Revise to:  
 "PPR2311"  
 (with no dashes or extras zeros or  
 extra spaces in the file number)

## EL PASO COUNTY GRADING AND EROSION CONTROL PLAN CHECKLIST

**GEC02**

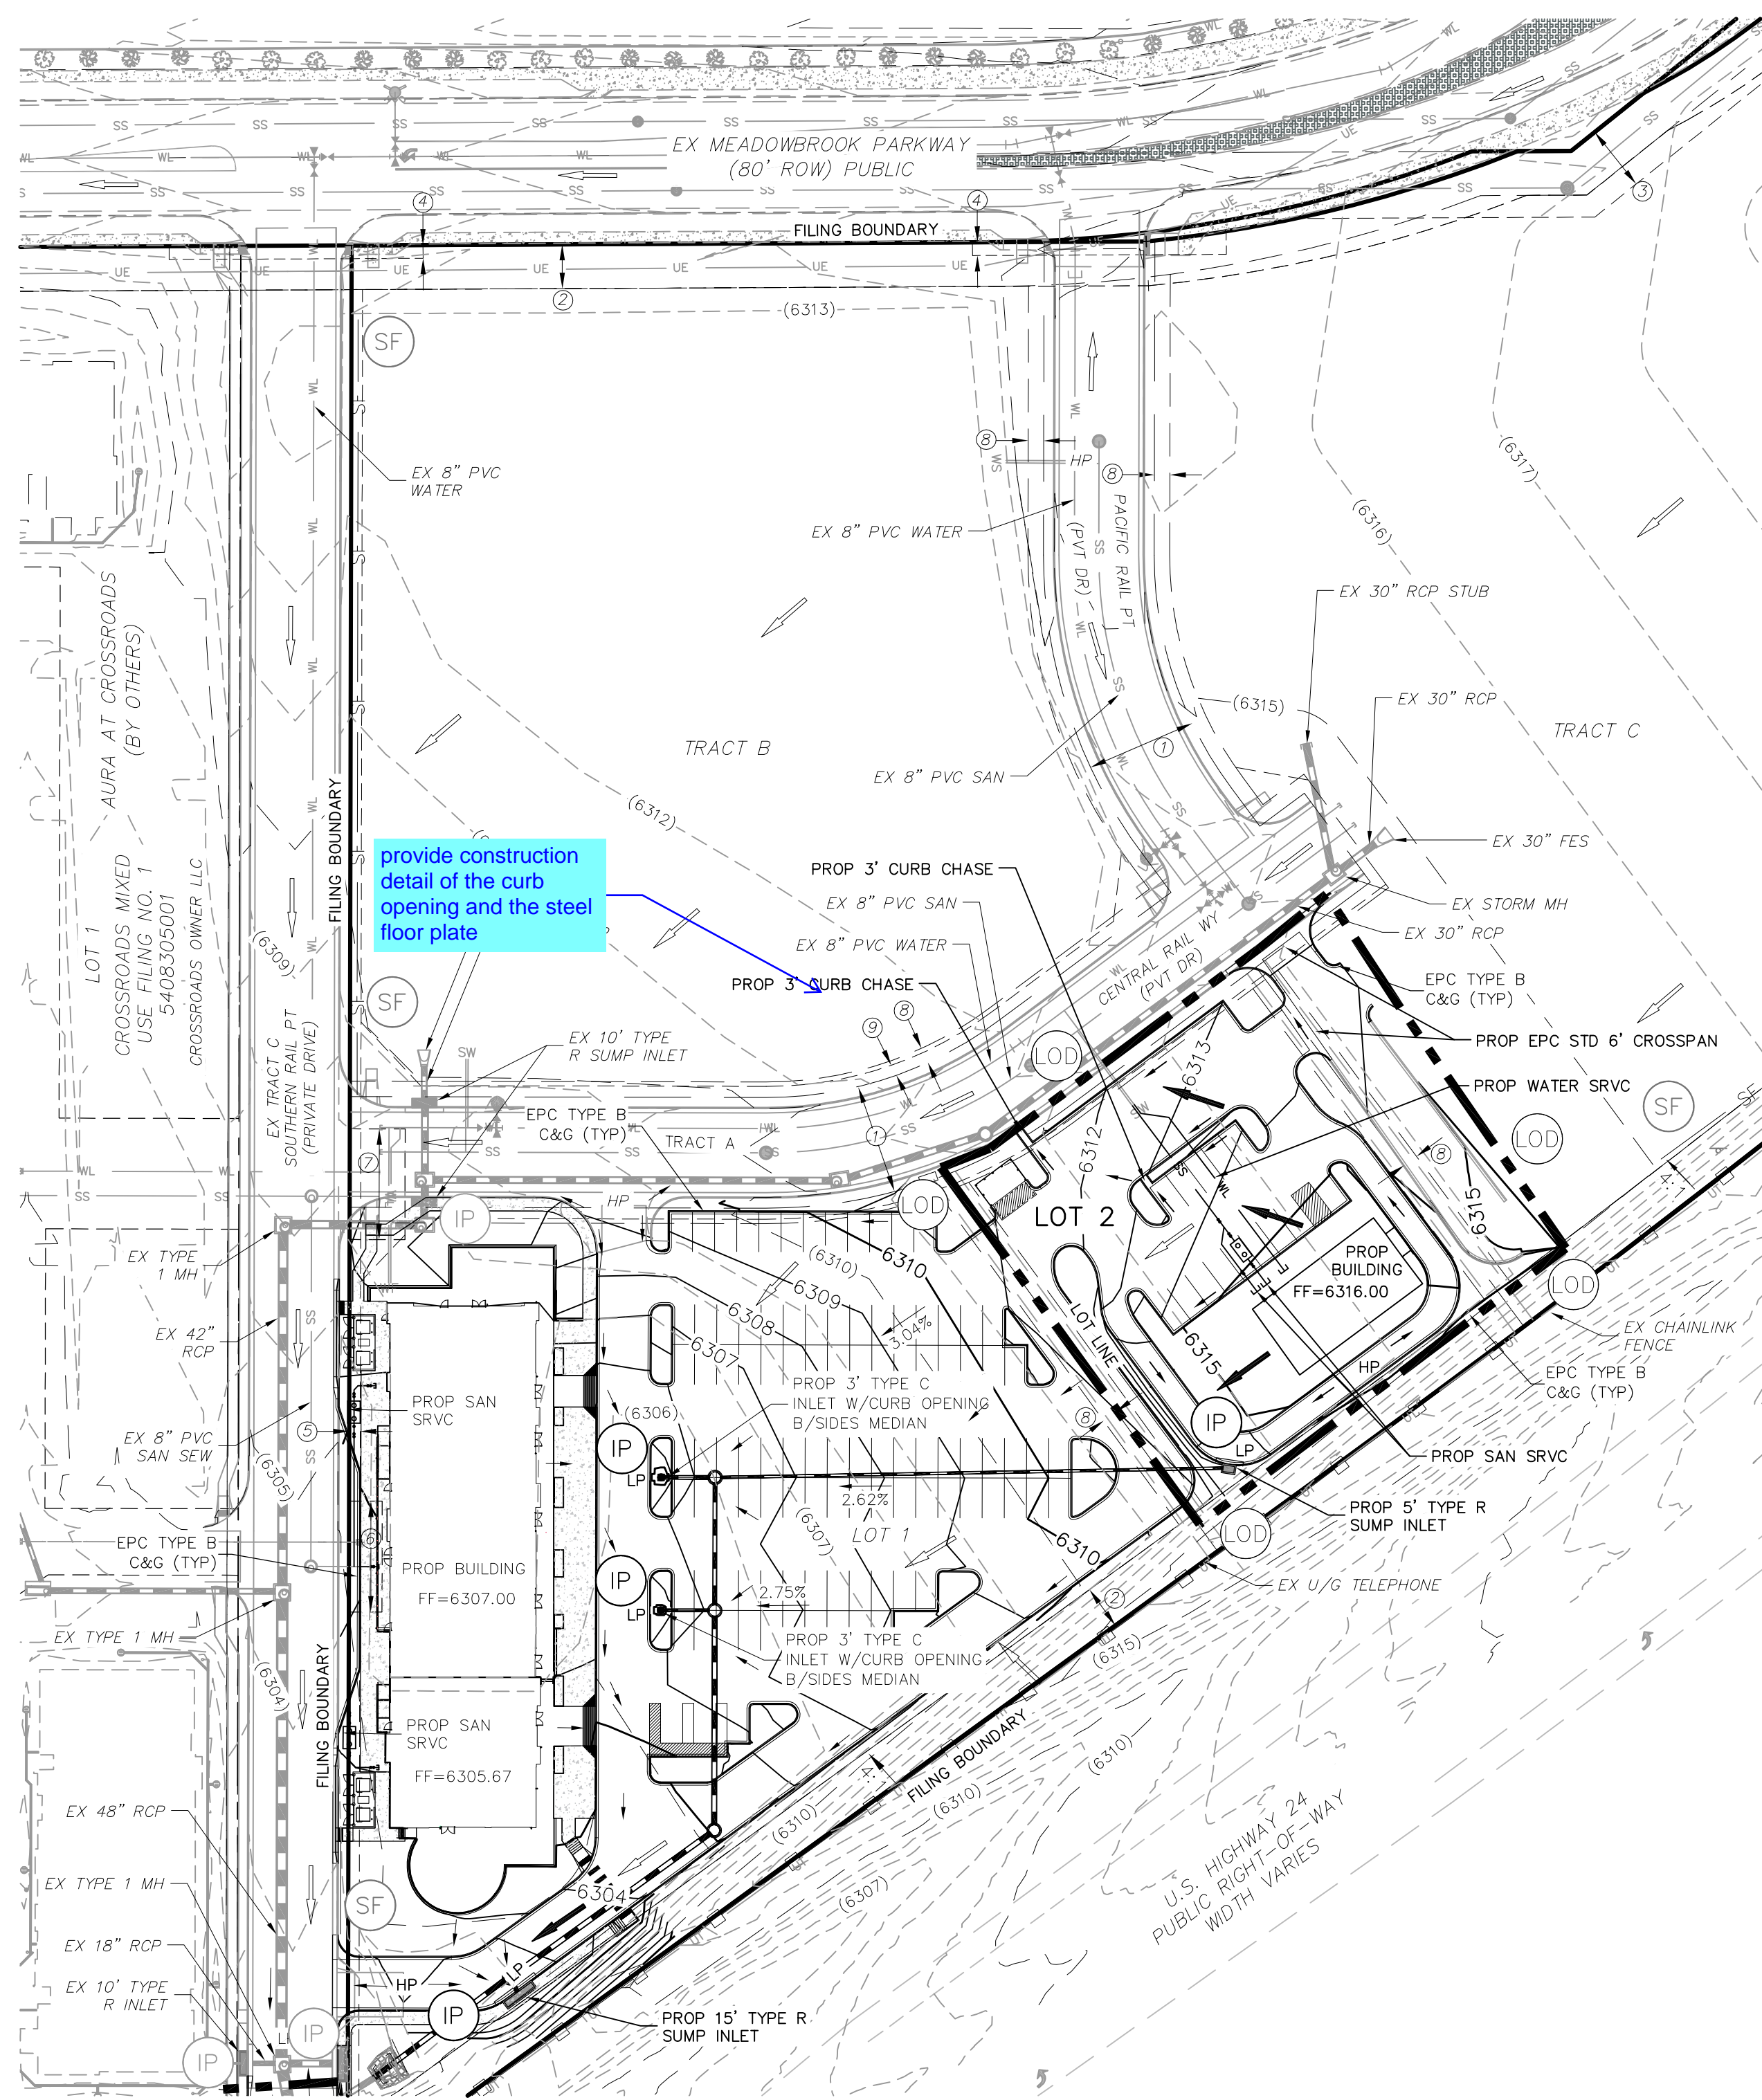
v	All proposed temporary construction control measures, structural and non-structural. Temporary construction control measures shall be identified by phase of implementation to include "initial," "interim," and "final" or shown on separate phased maps identifying each phase		Y
w	Vehicle tracking provided at all construction entrances/exits. Construction fencing, barricades, and/or signage provided at access points not to be used for construction		N
x	Temporary sediment ponds provided for disturbed drainage areas greater than 1 acre		Y

See my comment on Sht GEC02 of GEC Plans
